<p>Document and Applicants Reference (Examination Library Reference)</p>	<p>Comment</p>
<p>Highways England – Deadline 1 Submission - 6.7 Appendix 2.1 Lighting Assessment - Rev 1 (REP1-011)</p>	<p>Noted the reasoning behind not introducing lighting throughout the route. Notwithstanding any future reconsideration that there may yet be on safety grounds, this decision is welcomed from the point of view of emerging Local Plan Policy ENV 4 regarding the maintenance of dark skies in open countryside areas, especially within the zone of influence of the Dark Sky Park and the AONBs. Should there be any reconsideration of the lighting issue, any lighting introduced should follow lighting design guidance referred to in Policy ENV 4.</p>
<p>Highways England – Deadline 1 Submission - 6.22 Noise Addendum - Rev 0 (REP1-019)</p>	<p>In Table 1-4 – Local Planning Policy Relevant to Noise, the relevant Local Plan and Core Strategy policies seem to be satisfactorily addressed.</p>

<p>Highways England – Deadline 1 Submission - 7.8 Applicant’s Response to ExA’s First Written Questions - Rev 0 (REP1-032)</p>	<p>GEN1.8 We consider that the introduction of a footway/cycleway along the full length of the

© WSP UK Ltd

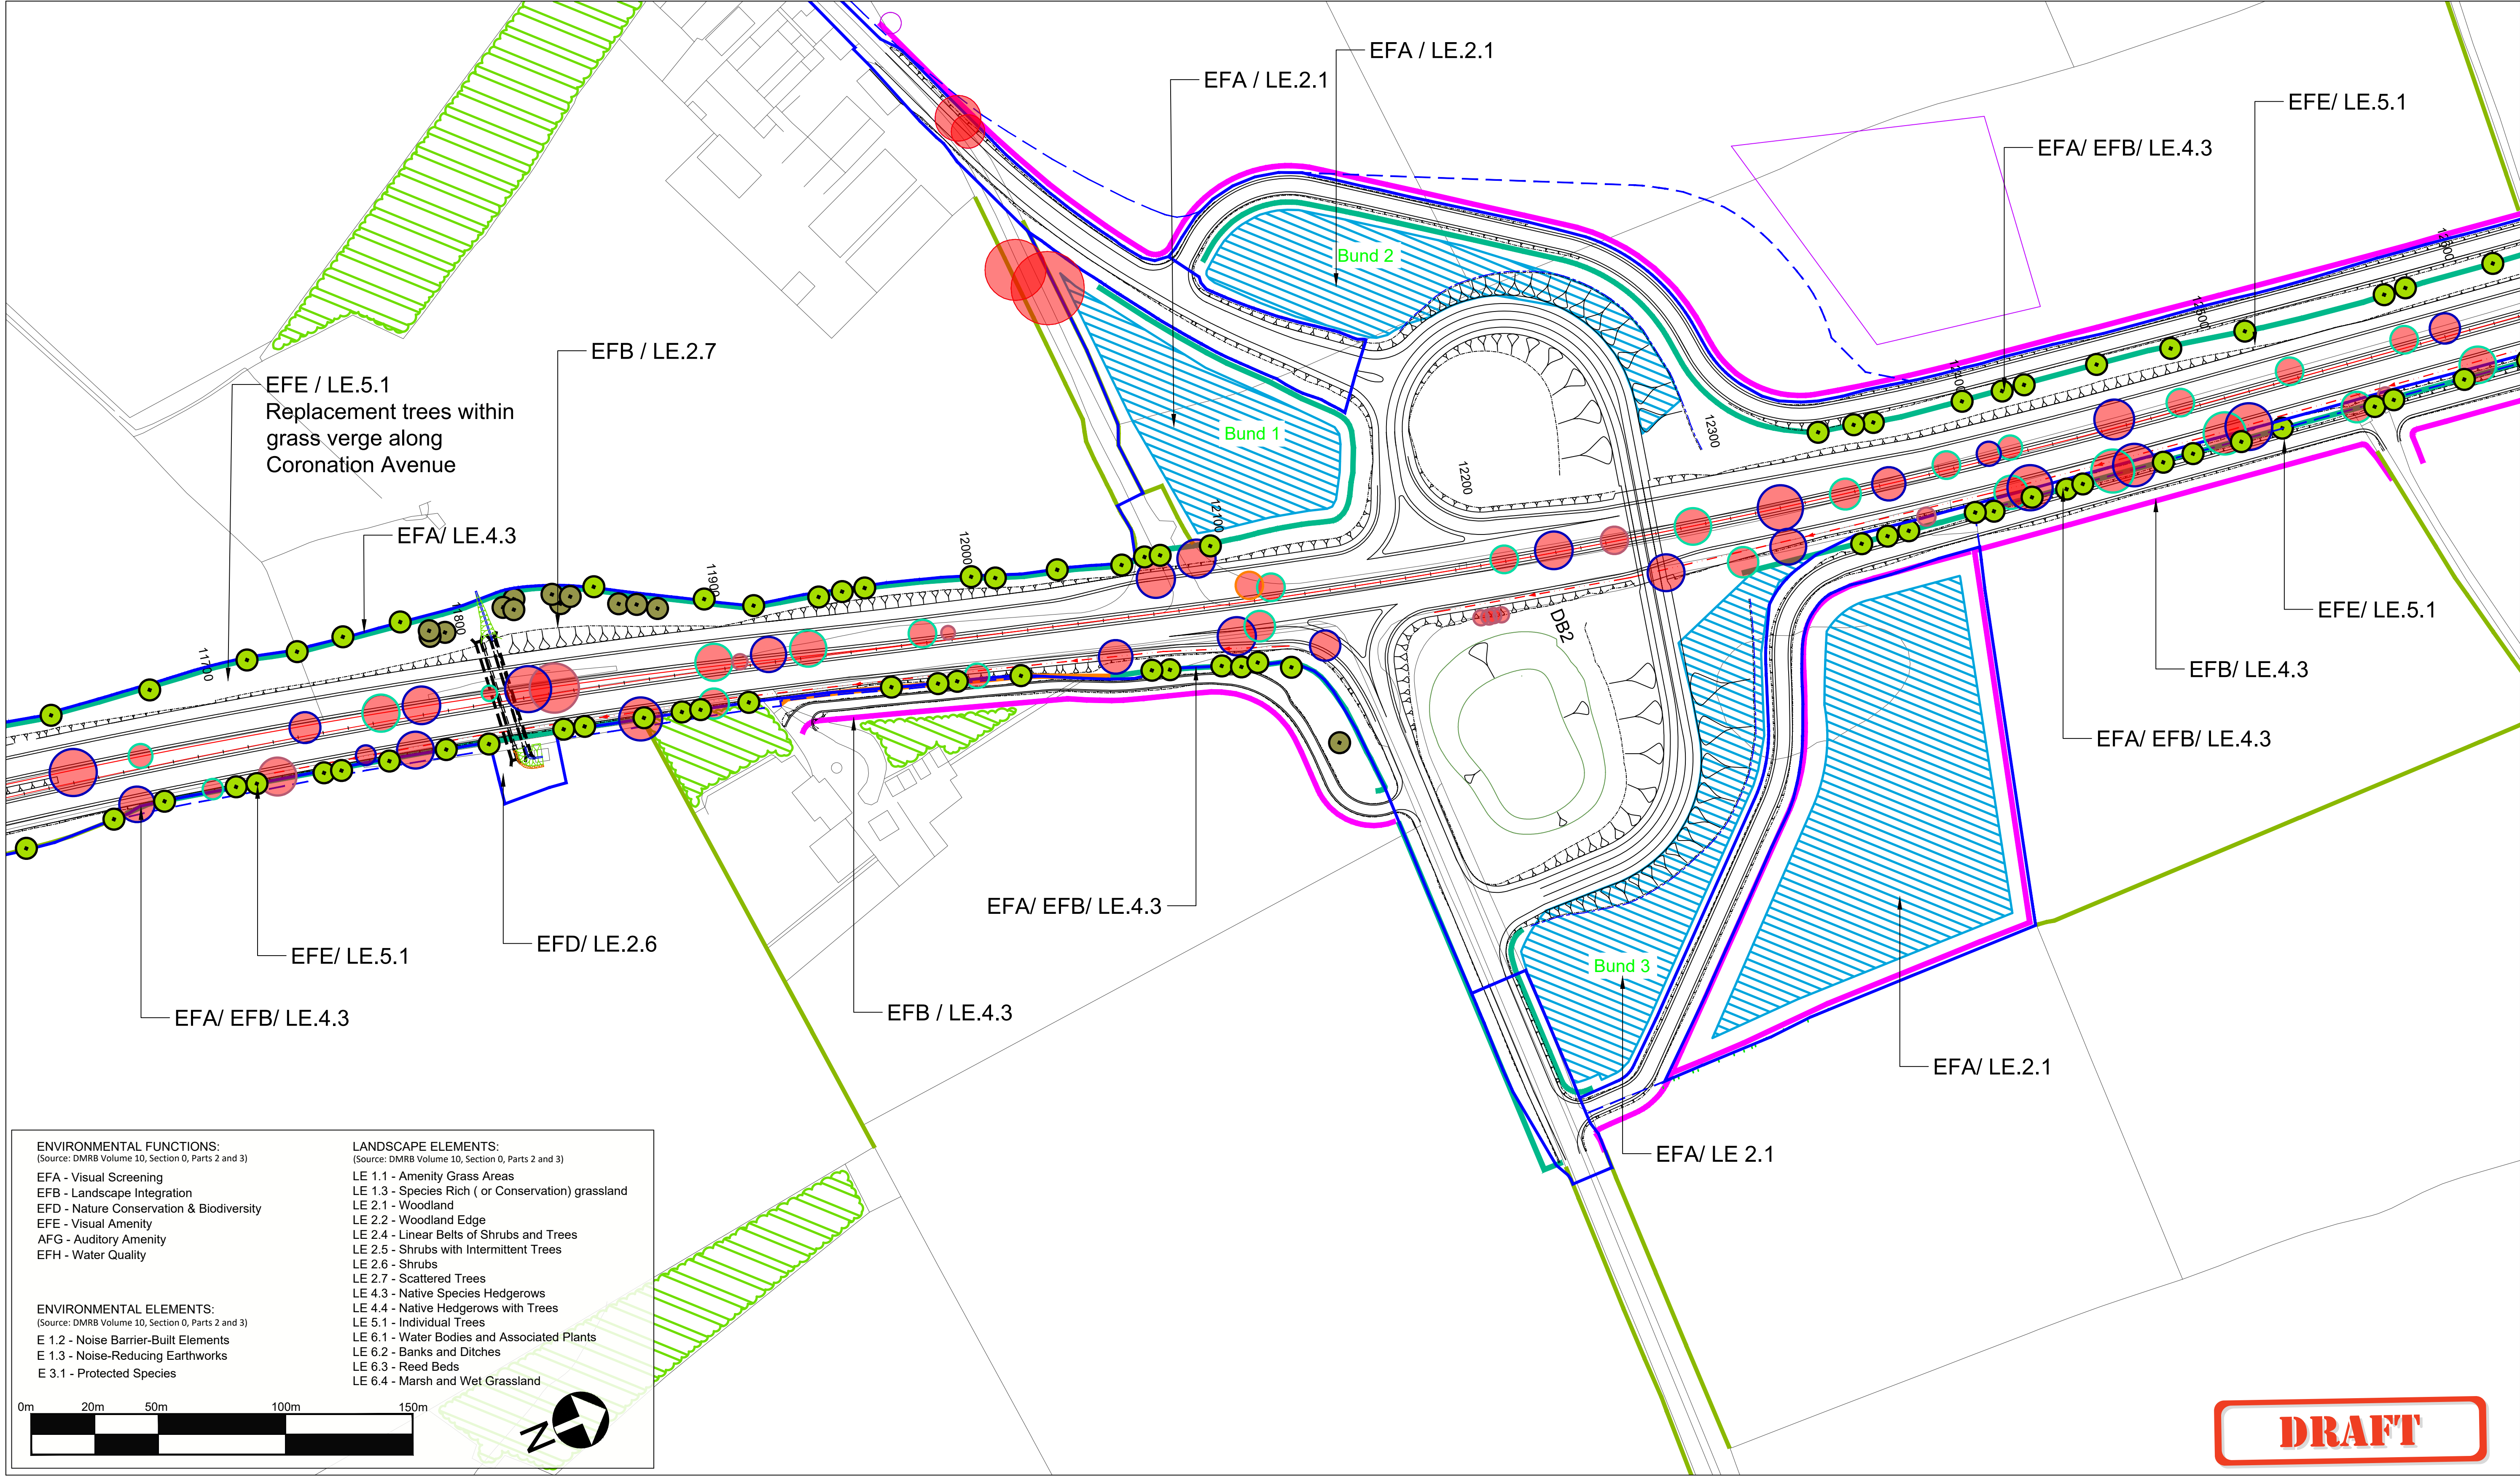
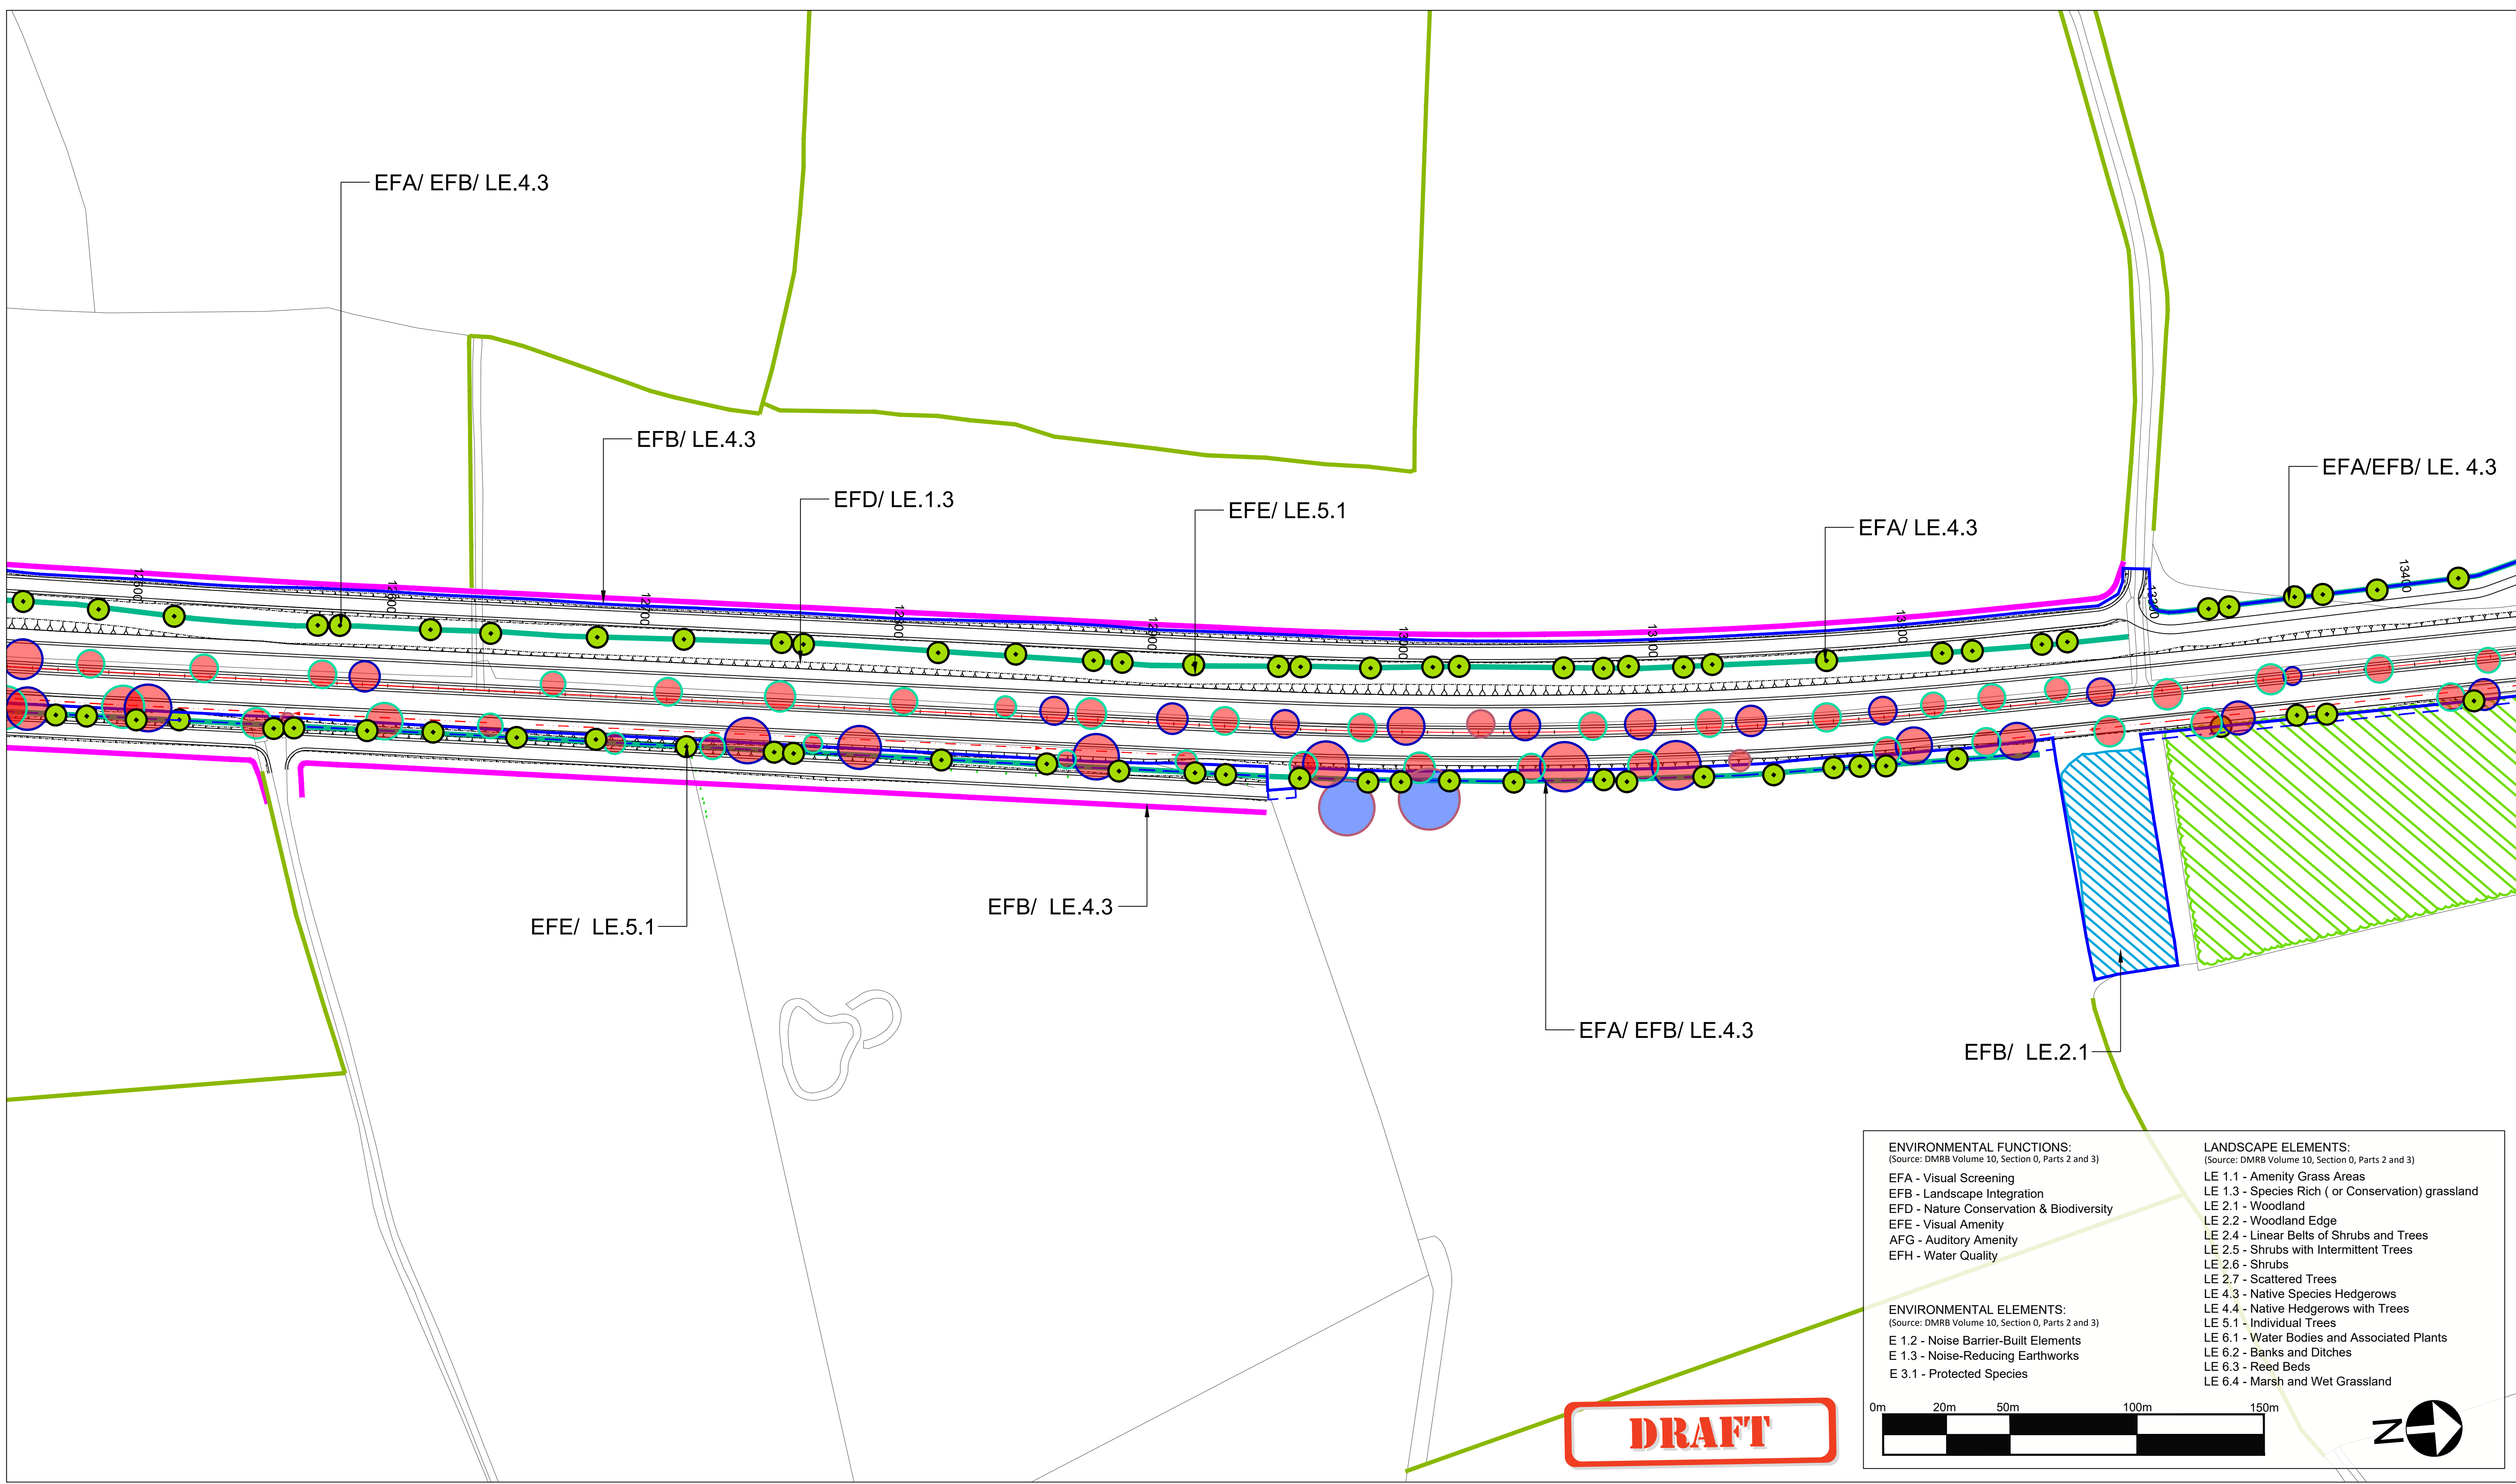
Document and Applicants Reference (Examination Library Reference)	Comment
Highways England – Deadline 1 Submission - 7.8.13 Appendix LV.2 Trees to be removed and replaced at Coronation Avenue (REP1-044)	As previously reviewed and agreed
Highways England – Deadline 1 Submission - 7.8.20 Appendix LV.1 Summary Table (REP1-050)	The schedule of vegetation removals has not been reviewed in detail. Will be discussed with applicant as part of Statement of Common Ground discussions.
Highways England – Deadline 1 Submission -7.8.21 Appendix LV.3 response to WQ LV 1.1.13 (REP1-051)	This document provides a specific response regarding potential further mitigation for significant effects on residential receptors. Several of these coincide with community receptors at West Moor (R35, R36 and R37) and Causey Park Bridge (R58 and R59) for which we have been requesting further consideration and mitigation (see above) and still consider despite the response given that improvements to mitigation could be made. Discussions with the applicant are ongoing on this matter
